TECHNICAL NOTE

Job Name: Fort Halstead
Job No: 41290
Note No: 5503 - TN02
Date: 28th May 2020
Prepared By: F Mott
Subject: Addressing KCC Comments Dated 22nd April 2020 and 19th December 2019

2. Comments from KCC Consultation Response 22nd April 2020

PROPOSED STAR HILL ROAD JUNCTION

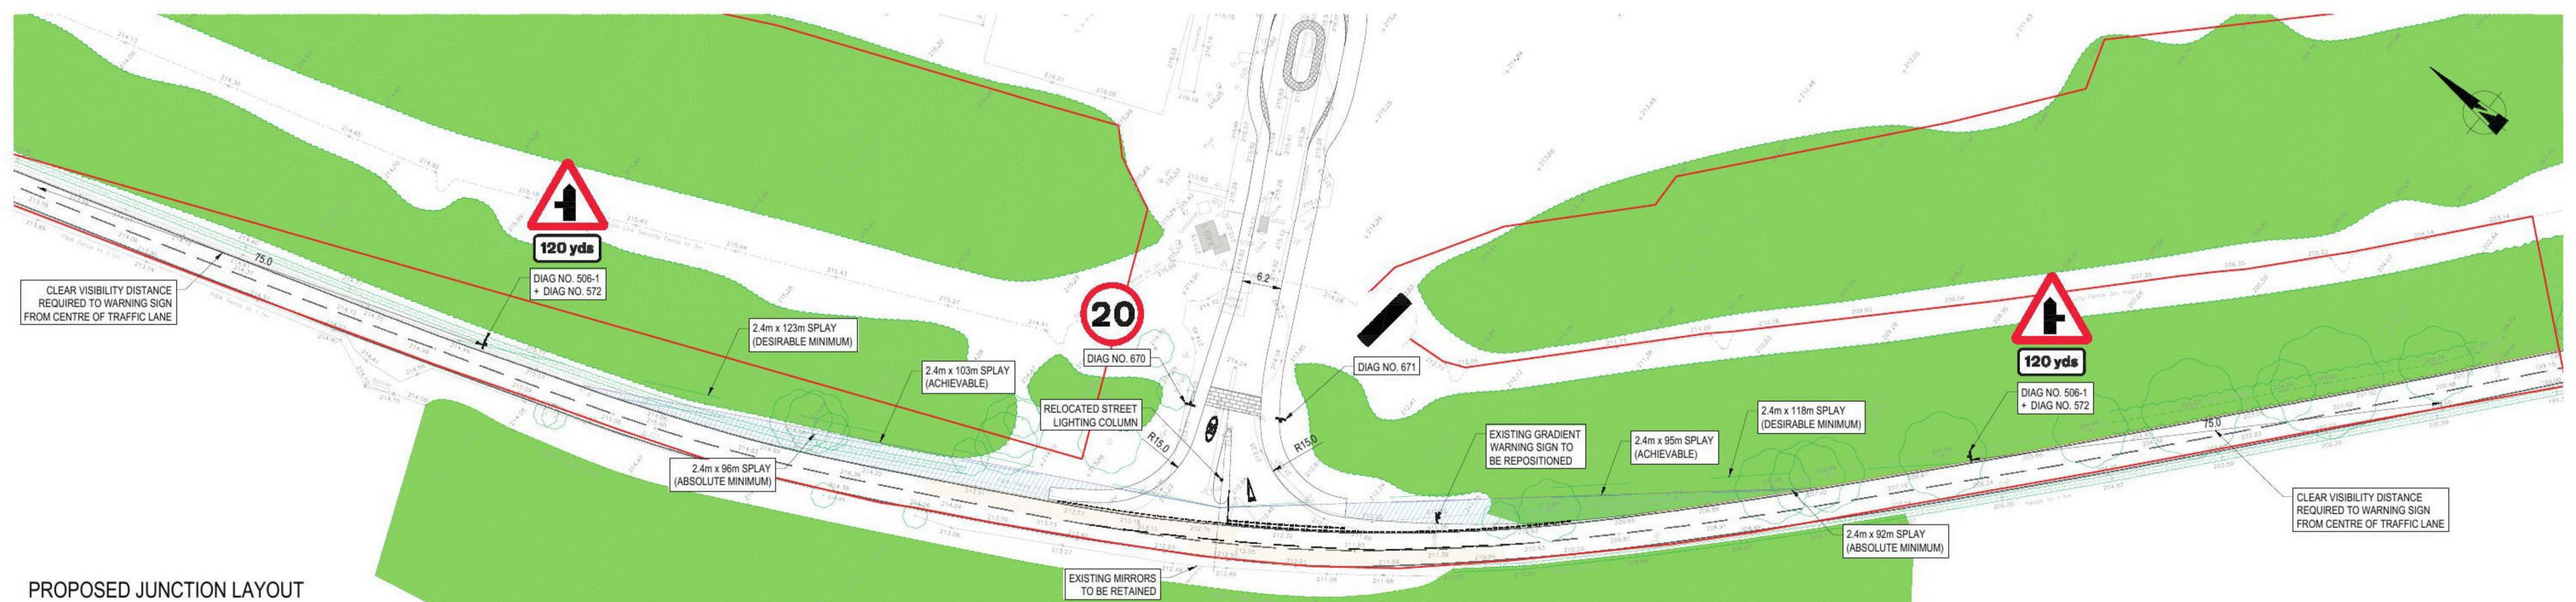
KCC Comment: “As previously noted, the visibility splays are considered appropriate for 37mph roads. The TA outlines that speed surveys do not go out of date, and remain fit for purpose. Part of the proposed works at Star Hill Road include a TRO to change the speed limit to 40mph, whereby the question remains as to whether visibility splays should reflect this change in speed limit.”

KCC Comment: “The visibility splays are adequate for the speed of traffic (subject to the trimming of the vegetation).

New warning signs at the approaches to the junction, the addition of anti-skid surfacing, tapers on the junction corner radii, an enlarged splitter island, cutting back of vegetation to improve visibility.

White lining and signs on the bend near the cottages on the south side of Star Hill road to warn of the bend have previously been requested and should be included as measures.

2.25. This comment has been addressed and can be seen in para 4.5.5 within the submitted TA. As set out in scheme drawings appended to the TA the recorded traffic speeds have been used to calculate appropriate visibility splays in accordance with the formula set out in Manual for Streets and IGN2. The proposed visibility splays are therefore considered to meet current design guidance.

2.26. This comment has been addressed and can be seen in para 4.5.6 within the submitted TA.
